From:
To: [Neil Bearcroft](#)
Cc: [DCAdmin](#)
Subject: Planning Application 2021/91239
Date: 07 July 2021 23:46:07

The plans appear to shift the proposed house at 410, 2.6m towards the proposed house at 412. The eastern edge of the new property will therefore be in the same location as the current bungalow and the plans attempt to show that it does not appear to encroach into the area in which trees with protection orders are located. Our concern is that the current arrangements to retain the soil on the banking will be compromised by the additional weight of the 2 storey house that is proposed and deeper foundations for the retaining wall will be required. This would be likely to damage tree roots and therefore destroy the protected trees over time. Even if the eastern edge of the new property is in line with the old one, the rebuilding will require heavy plant and machinery in the area where the trees and woodland are subject to TPOs. Any disturbance in this area will cause tree damage.

Proposed Site Layout Plan

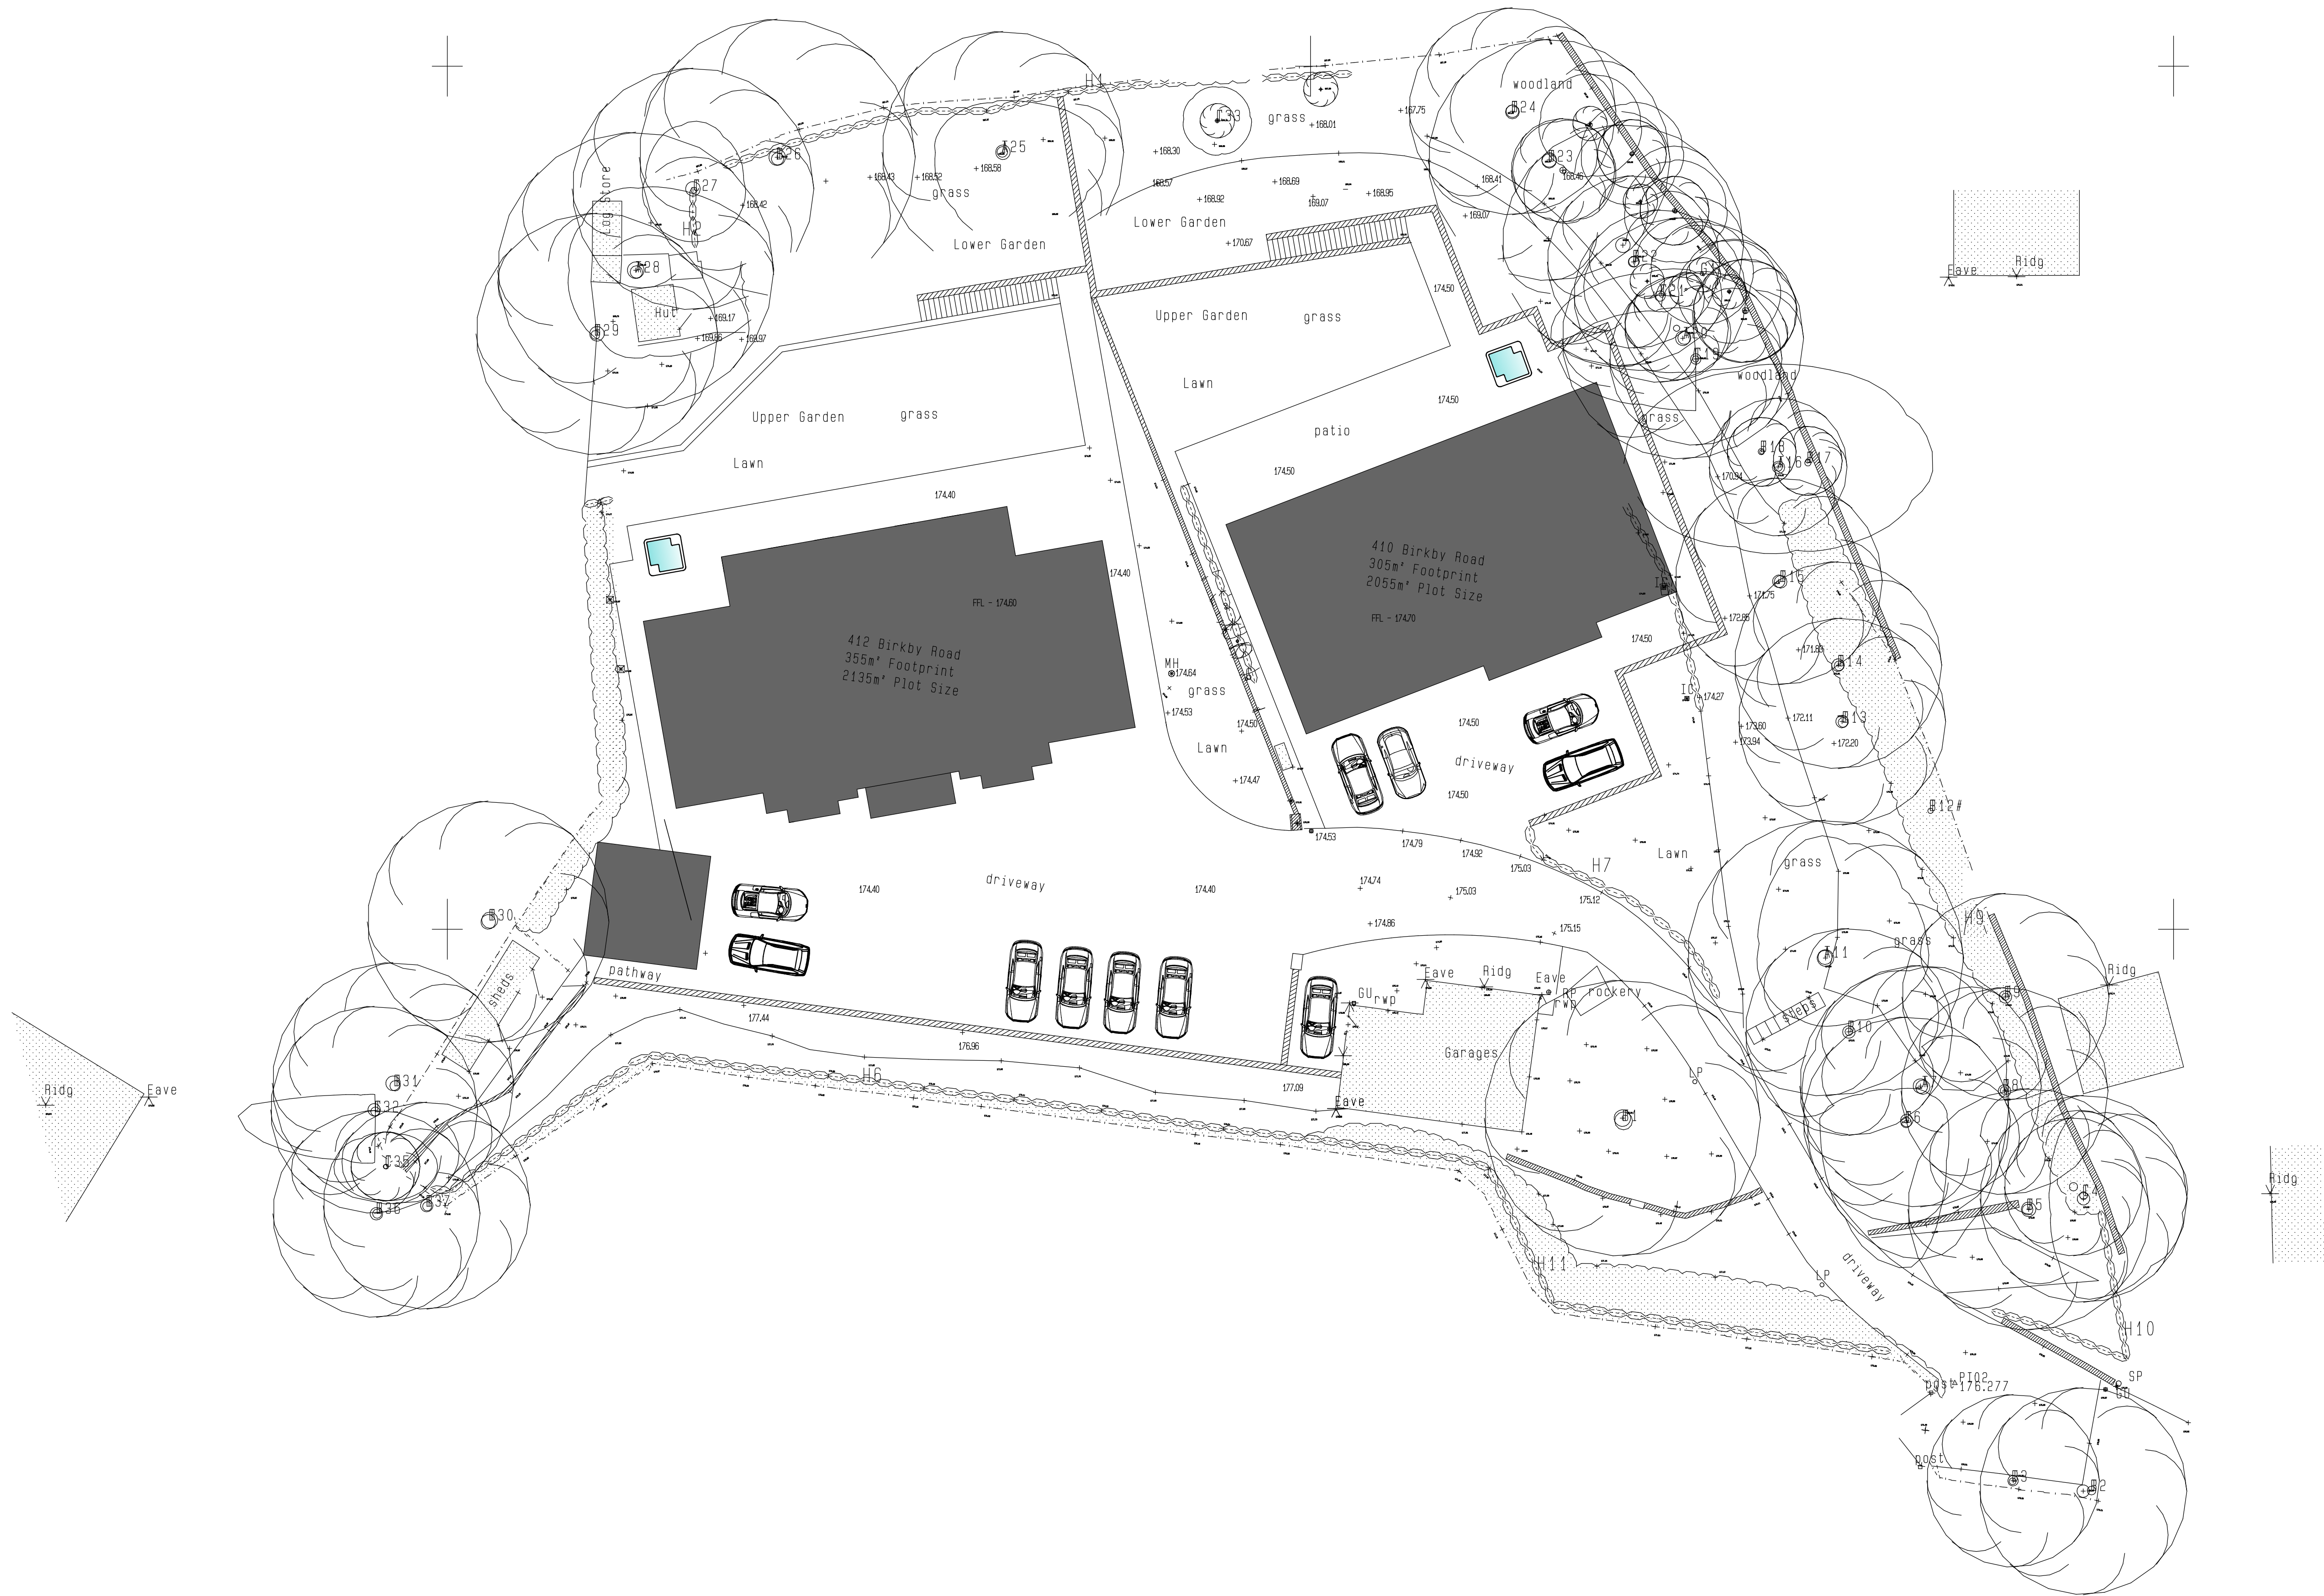
There is no change in the size, bulk or height of 410 and by moving this house much closer to 412, it creates a very narrow space between the two houses. Plan 212112B shows the front of the houses will be 5.4 m apart but the gap narrows towards the rear of the properties by a further 2 metres. Such a close relationship between the two buildings is inappropriate and the revised location will be overbearing in terms of its design and scale alongside proposals for 412. The plot for 410 and 412 may look large on paper, but due to the topography, the available building space is much smaller and the new houses much larger, taller and more imposing resulting in the potential over development of the plots. LP24 (b) "requires proposals to provide a high standard of amenity for future and neighbouring occupiers, maintaining appropriate distances between buildings." The current applicants are relatives, and this may not be an issue for them, but the national planning framework, and Kirklees Local plan is clear that proposals should consider future occupiers.
